**CITY OF PORTLAND, MAINE
DEVELOPMENT REVIEW APPLICATION
PLANNING DEPARTMENT PROCESSING FORM**

Kansas Ave. Lot# 23

BUILDING PERMIT REPORT

DATE: July 2001 ADDRESS: 82 Kansas Ave. (G#2) CBL: 399-D-008

CONCEPTUAL GRADING PLAN; SCALE 1"=30'
 LOT 23 PINES (82 KANSAS AVE.)
 PLOT PLAN Prepared By Greg McCormack
 Based on Grading Plan Prepared
 by PINKHAM+Greer ENGINEERS
 Dated 9/10/99

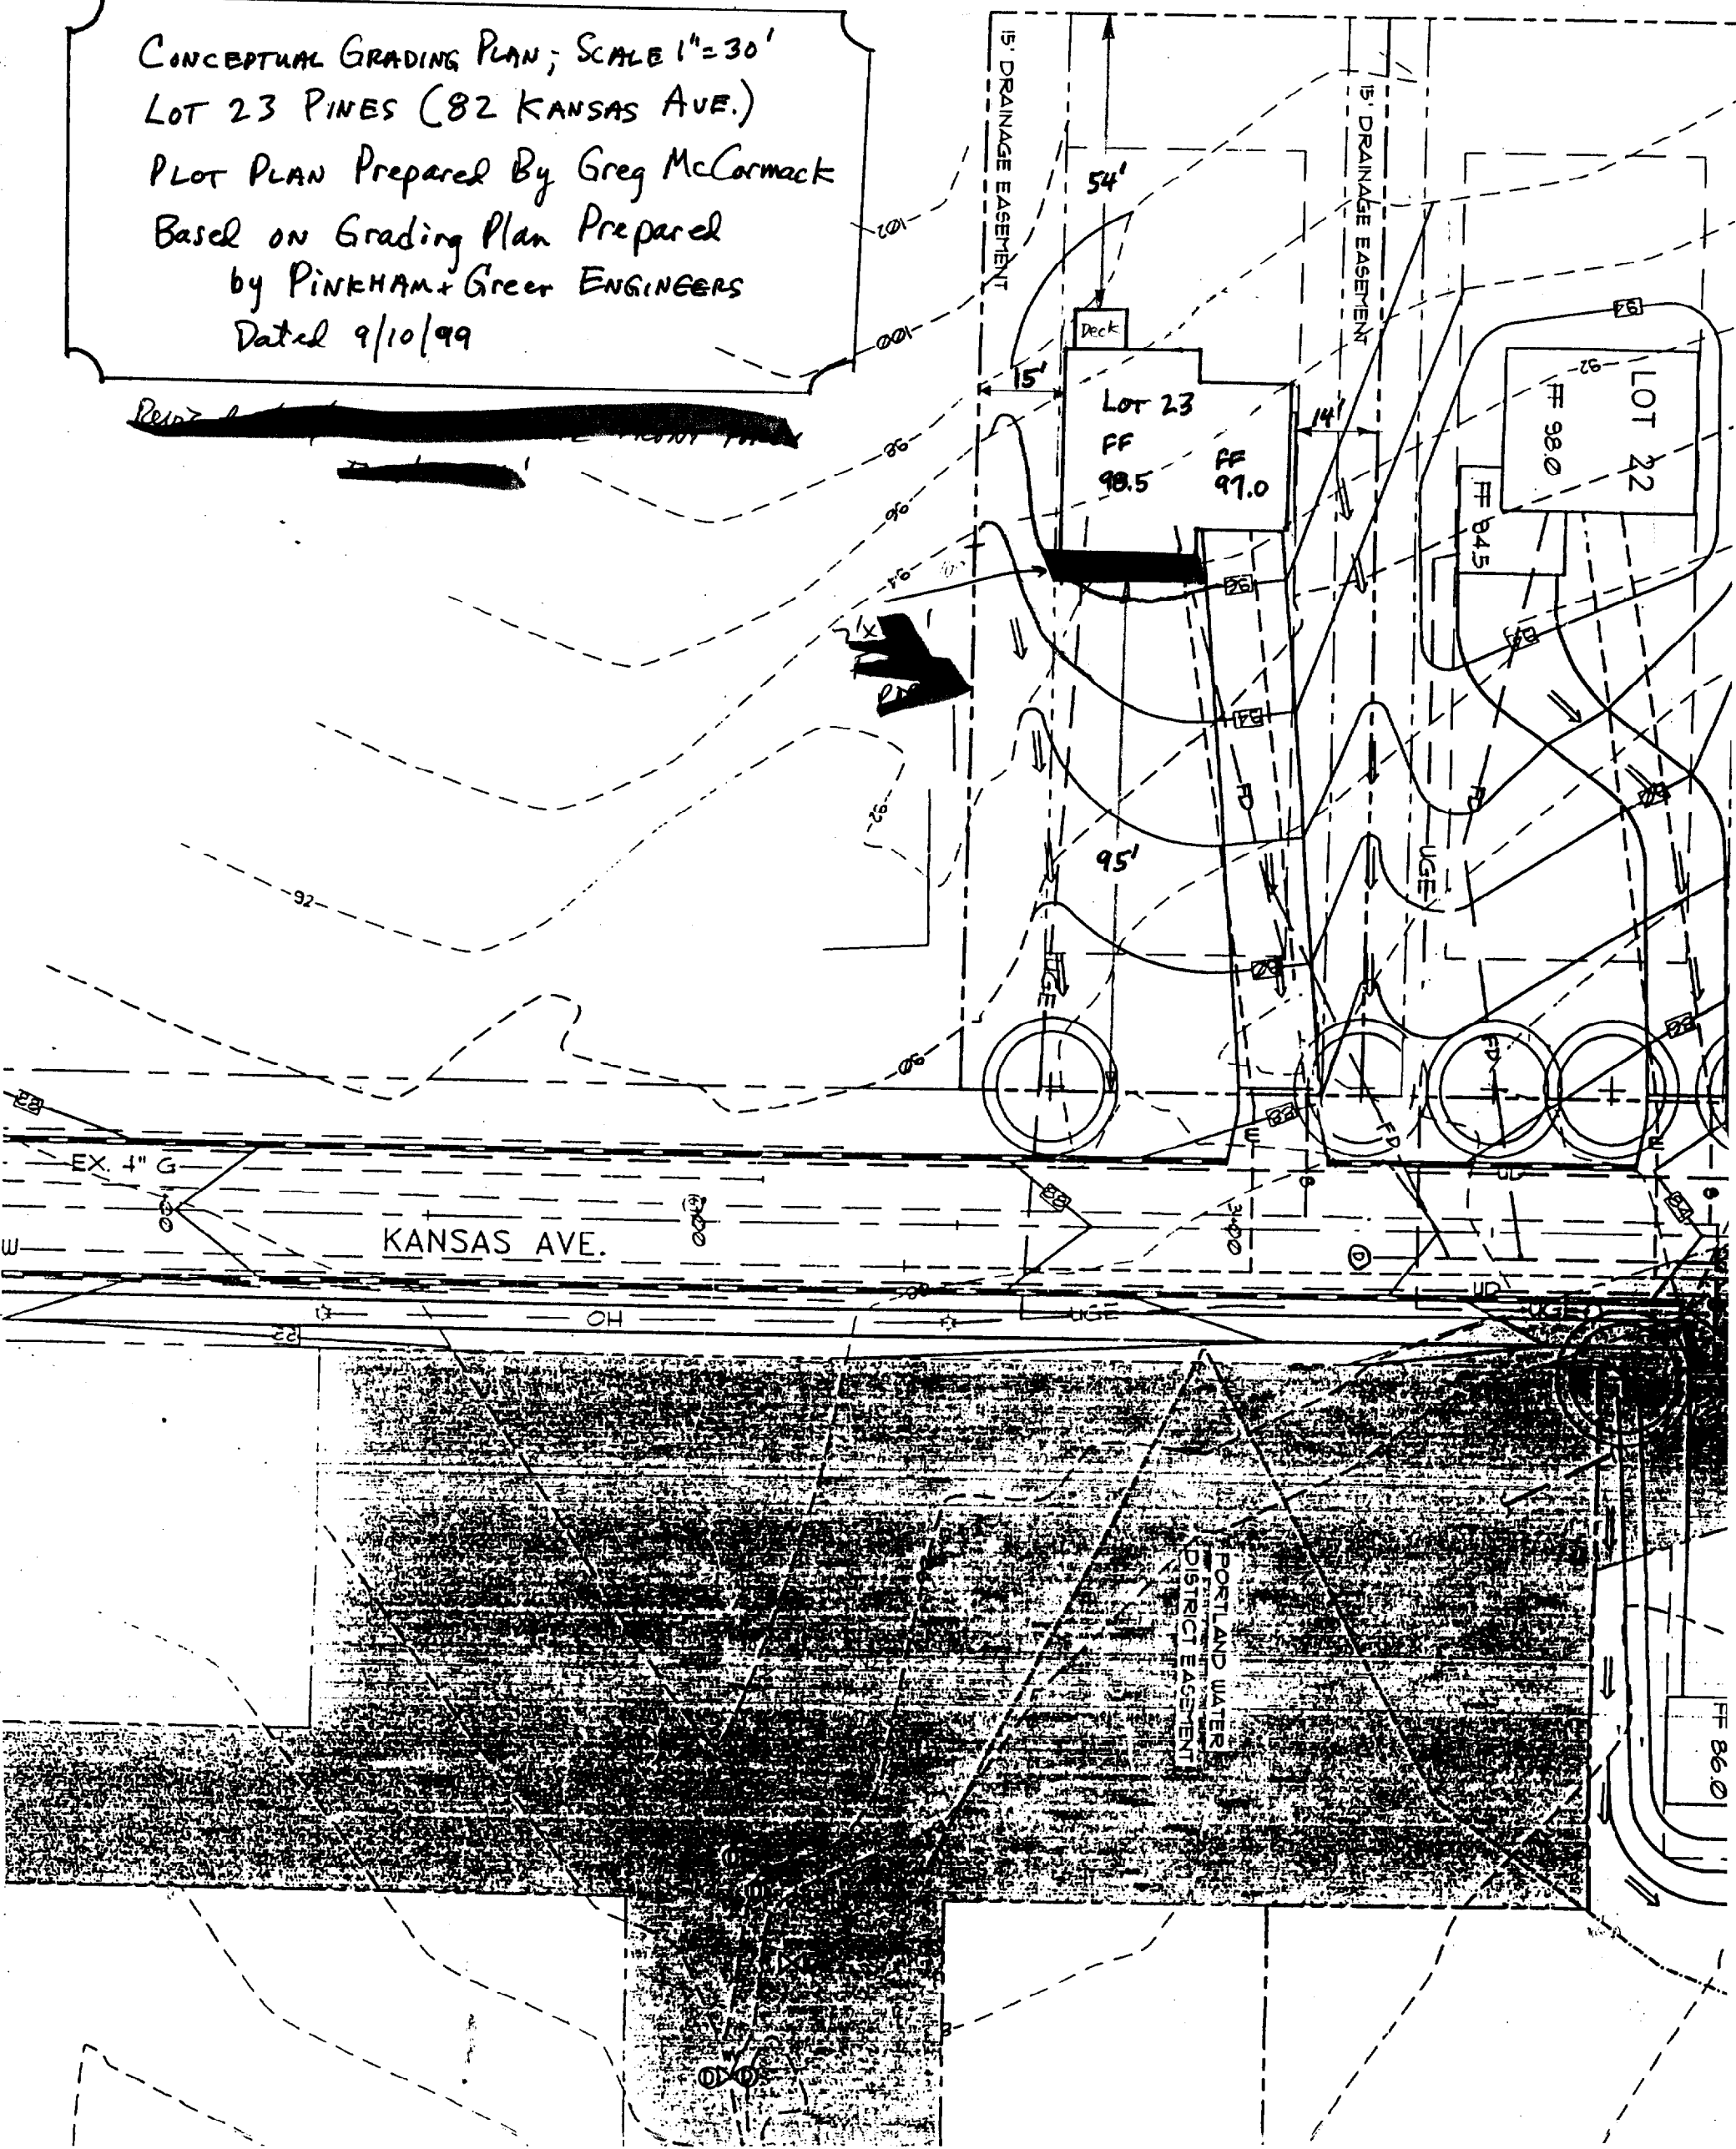
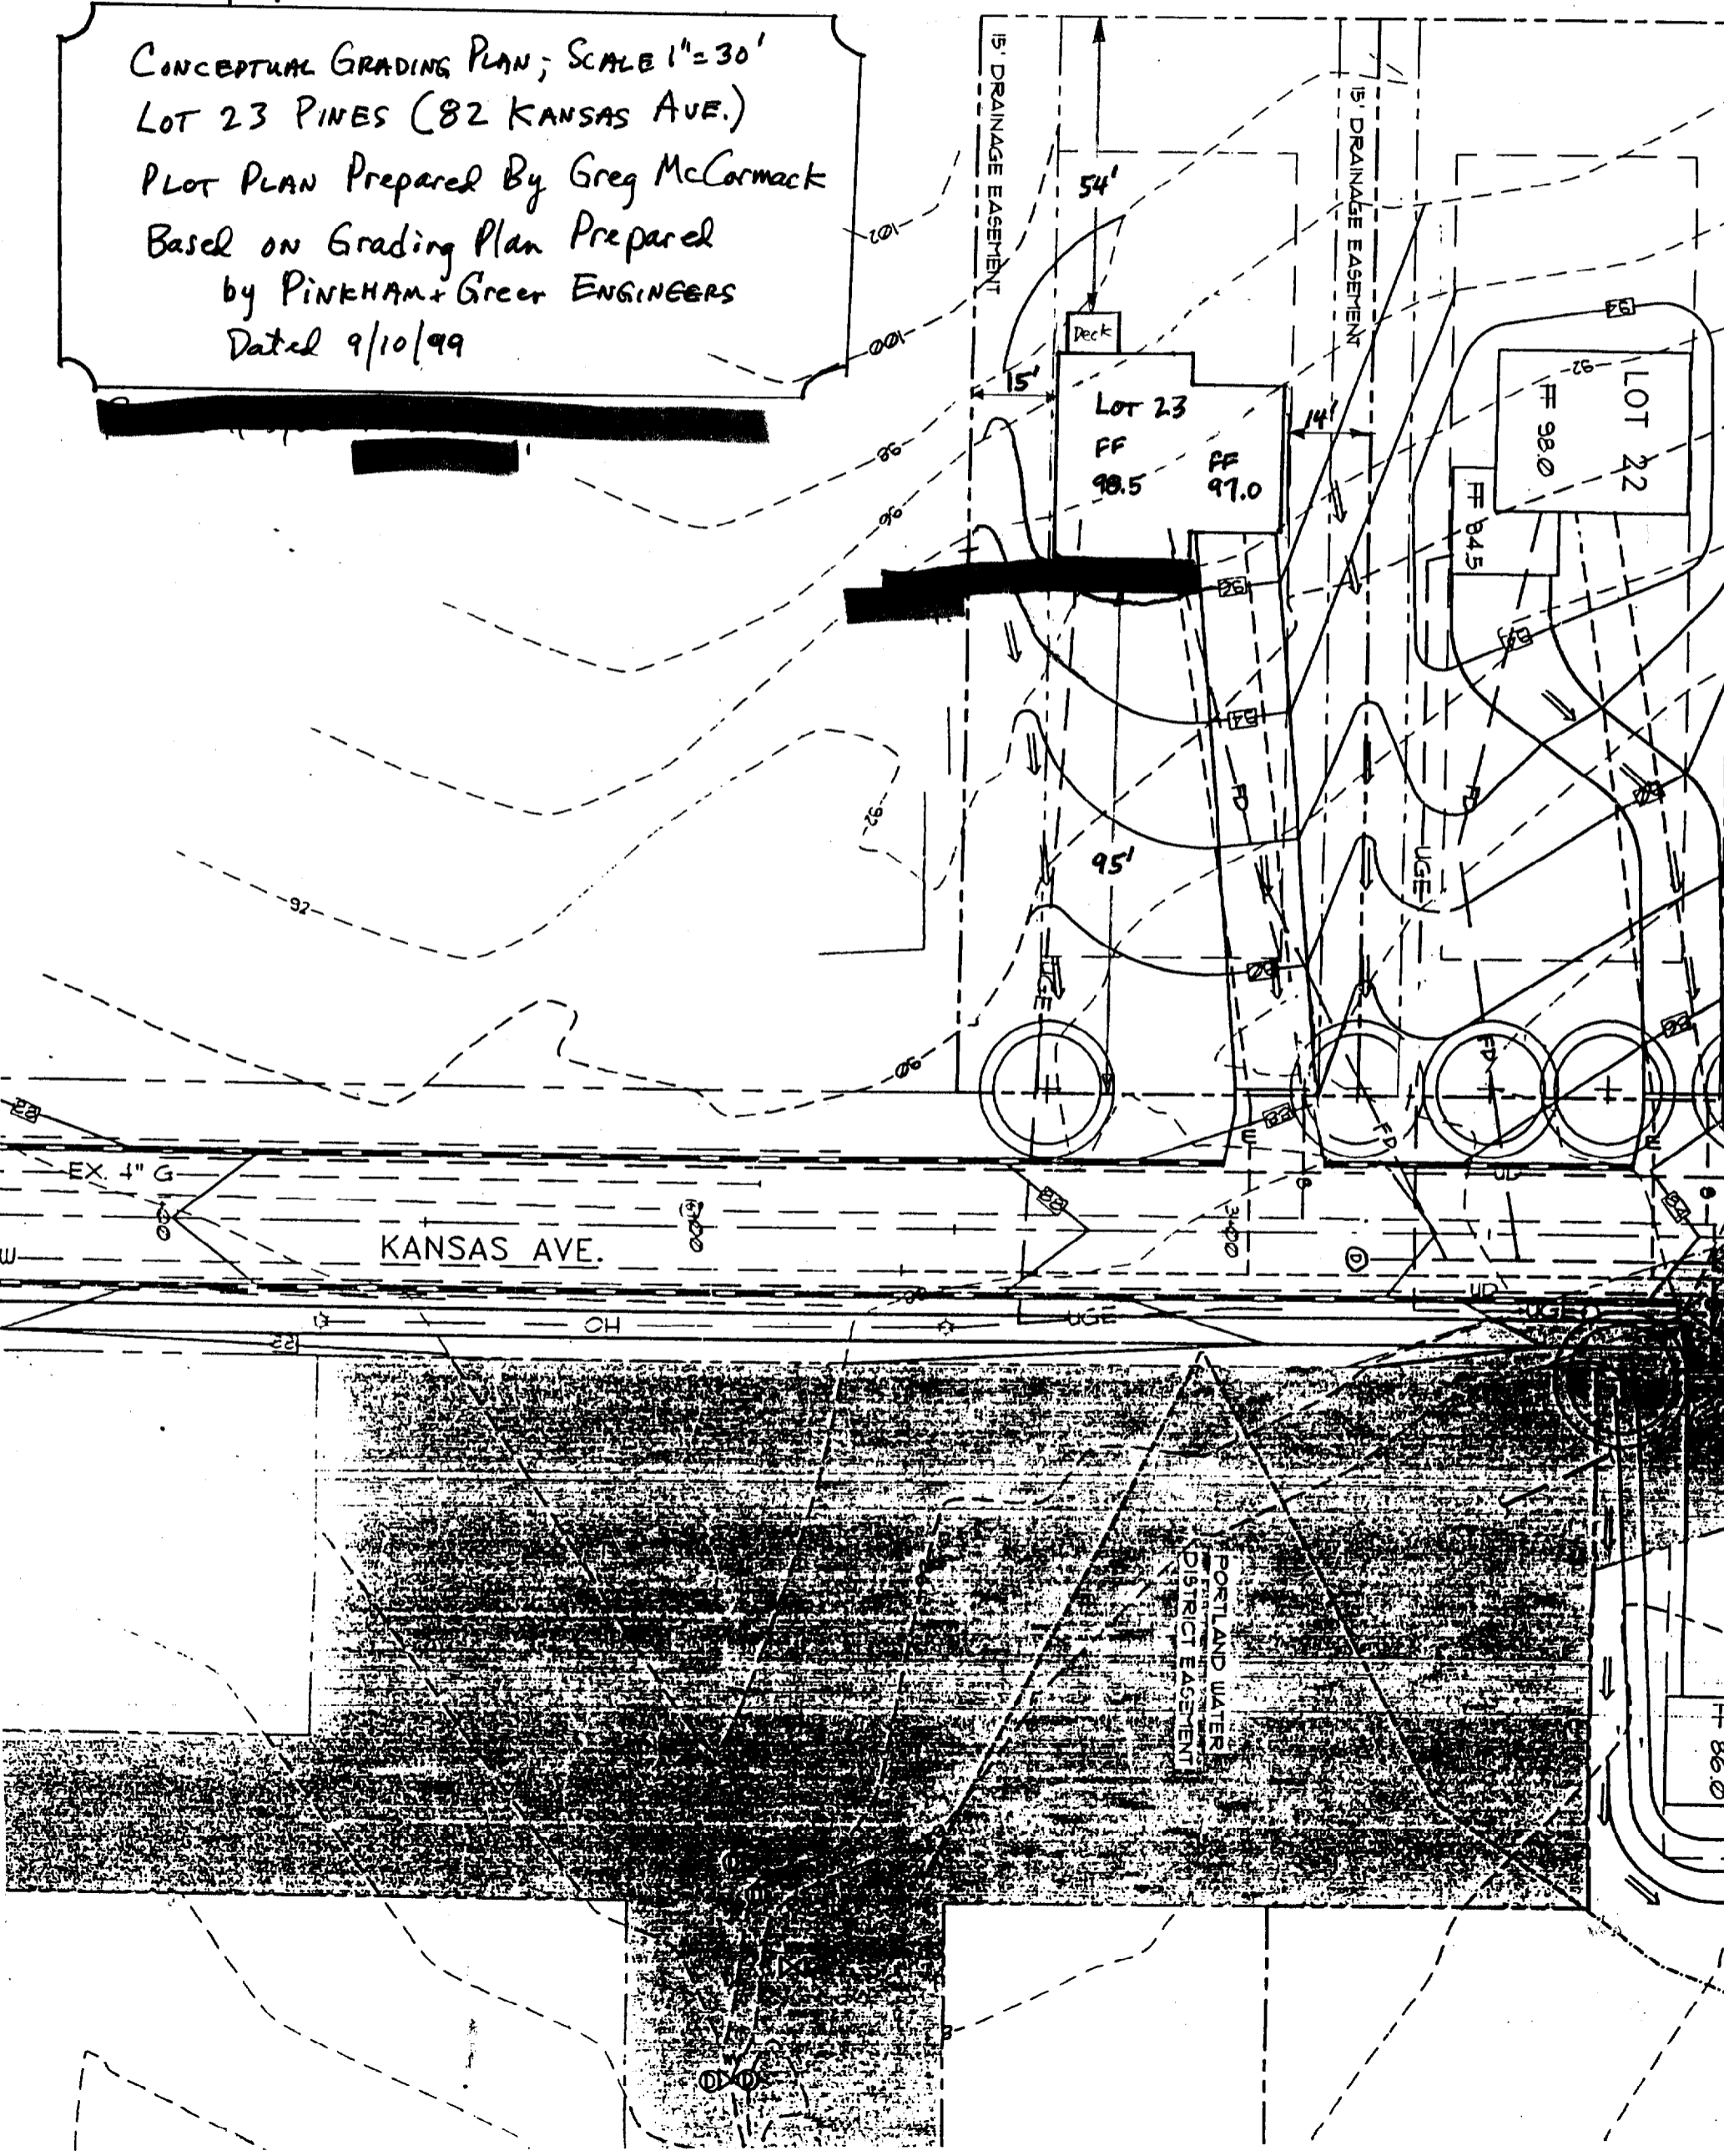
- 11 The building contractor shall check the subdivision recording plat for pre-determined first floor elevation and establish the first floor elevation (FFE) and sill elevation (SE) to be set above the finish street/curb elevation to allow for positive drainage away from entire footprint of building.

- 12 The site contractor shall establish finish grades at the foundation, bulkhead and basement windows to be in conformance with the first floor elevation (FFE) and sill elevation (SE) set by the building contractor to provide for positive drainage away from entire footprint of building.

- 13 A drainage plan shall be submitted to and approved by Development Review Coordinator showing first floor elevation (FFE), sill elevation (SE), finish street/curb elevation, lot grading, existing and proposed contours, drainage patterns and paths, drainage swales, grades at or near abutting property lines, erosion control devices and locations and outlets for drainage from the property.
